<b>Consultation Response from KC Waste Strategy (Refuse &amp; Cleansing)</b>		
<b>PA no. &amp; address:</b> 2020/92067 former, Stile Common Infant & Nursery School, Plane Street, Newsome, Huddersfield, HD4 6DF		
<b>Proposal:</b> Erection of 30 dwellings		
<b>Date Responded:</b> 04/08/2020	<b>Responding Officer:</b> Carol Oakden	<b>Responding Ref:</b> WPS-20-023

Plots 27 and 28 First Floor Plan  
1 : 100

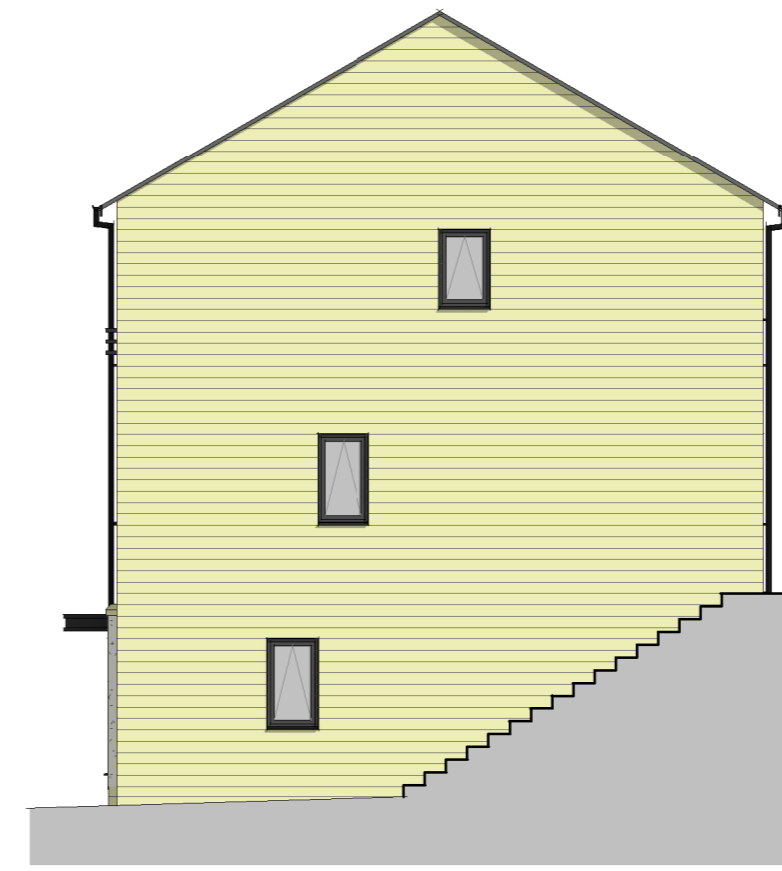
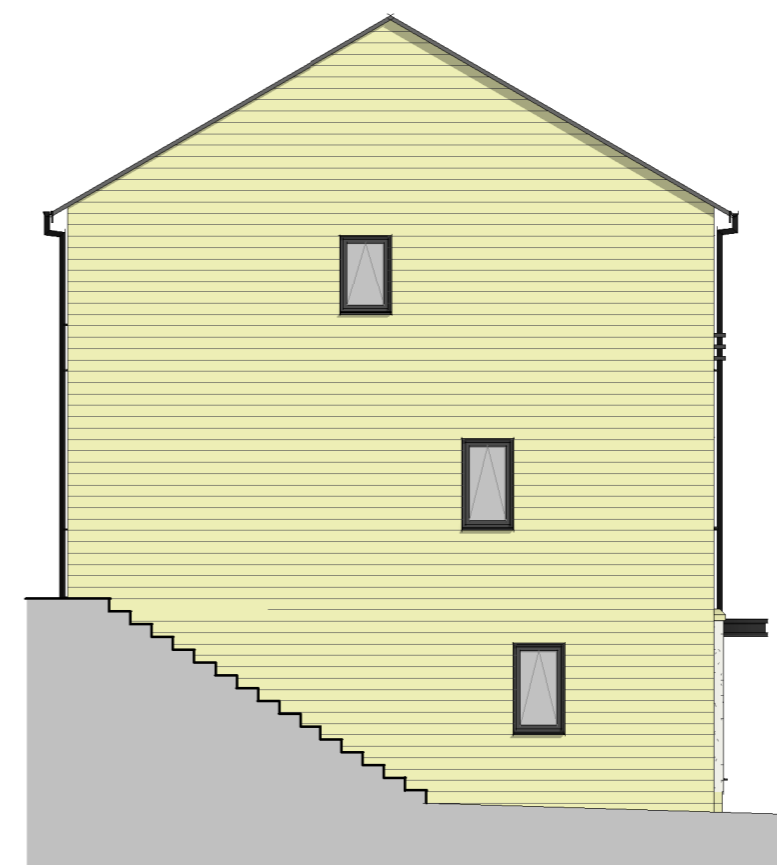
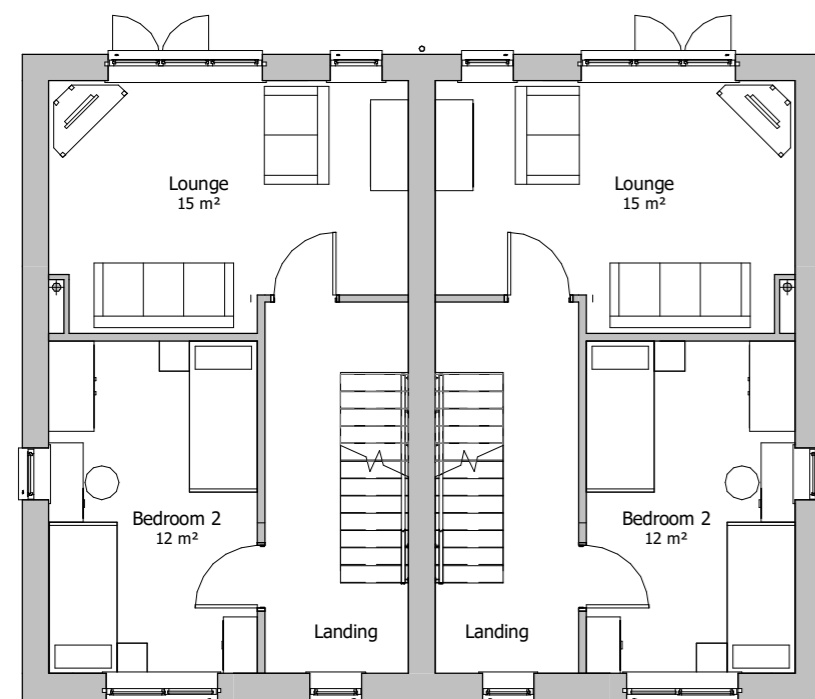
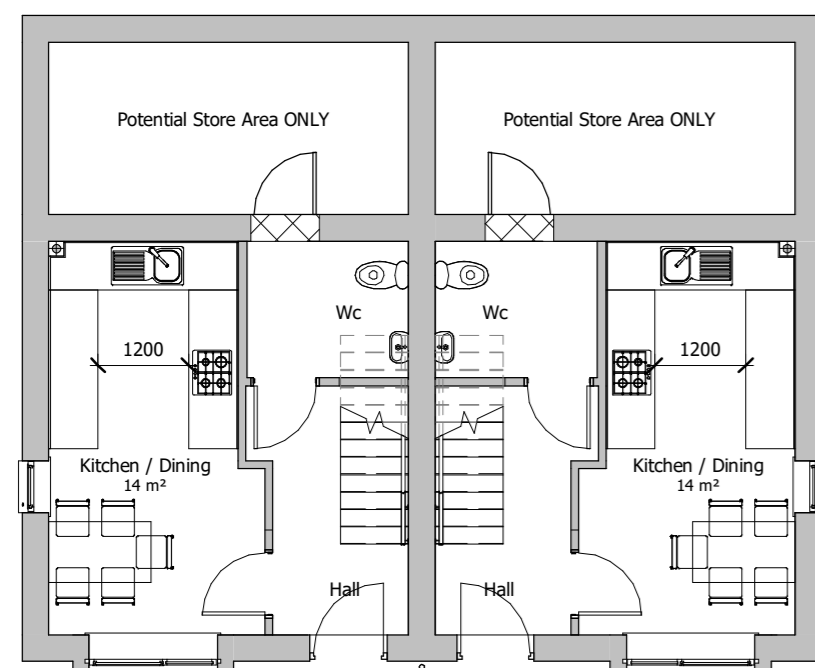
- Consideration has been given to the position of bin storage areas for all properties and these account for the changing levels on the site. Split level plots on the south side of the proposal have bin storage indicated to the front of properties to negate the need to take bins up/down steps to reach rear gardens. However, all storage areas only show space for 2 x 240ltr bins. Additional space for a third bin for garden waste is recommended when properties have private gardens.

- Front storage space for bins is recommended to have suitable screening/enclosure to reduce visual impact on the streetscene and to help prevent unauthorised use, theft/damage and the escape of waste into the street. The design of the storage spaces is not clear in this regard.

**“Before development commences, details of suitable storage, bin presentation points and access for collection of wastes from the dwellings hereby approved shall be submitted to and approved in writing by the Local Planning Authority. The**

approved details shall be provided before first occupation and shall be so retained thereafter.”
